Re. Planning application 3/2025/0114

PROPOSED
SIDE ELEVATION

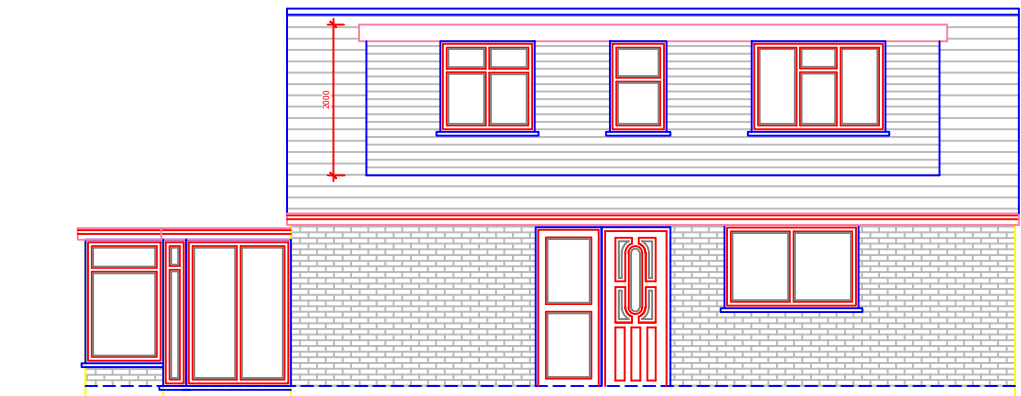
Being the most affected by this application (), we wish to register our objection to it. The builder who has bought it to renovate, and presumably sell for the maximum profit he can get, plans to almost double the size of the property with large dormers that look directly out from each side, rather than facing the road. Whilst many bungalows on this estate have already had dormers fitted, they are generally of a much smaller scale and facing the road.

If this project went ahead it would feel like the property would totally () and completely remove any feeling of privacy that () has. These bungalows were generally built to give a degree of privacy, with door and windows on just one of the sides, facing the plain brick wall of the adjacent property. The proposed dormer windows of this property would tower over () as well as looking totally out of proportion to the original concept of these bungalows. It would essentially become a 2 storey house. The dormer would also reduce the amount of daylight ()

and bathroom in the shade which for the past () has been a high level of privacy. () is located above ours due to the incline of Kirkdale Road, and with a roof planned to be higher than the main house () to show the proximity of the bungalows (). () attractive, the proposed increase in height, with windows directly above us, would feel oppressive and intimidating.
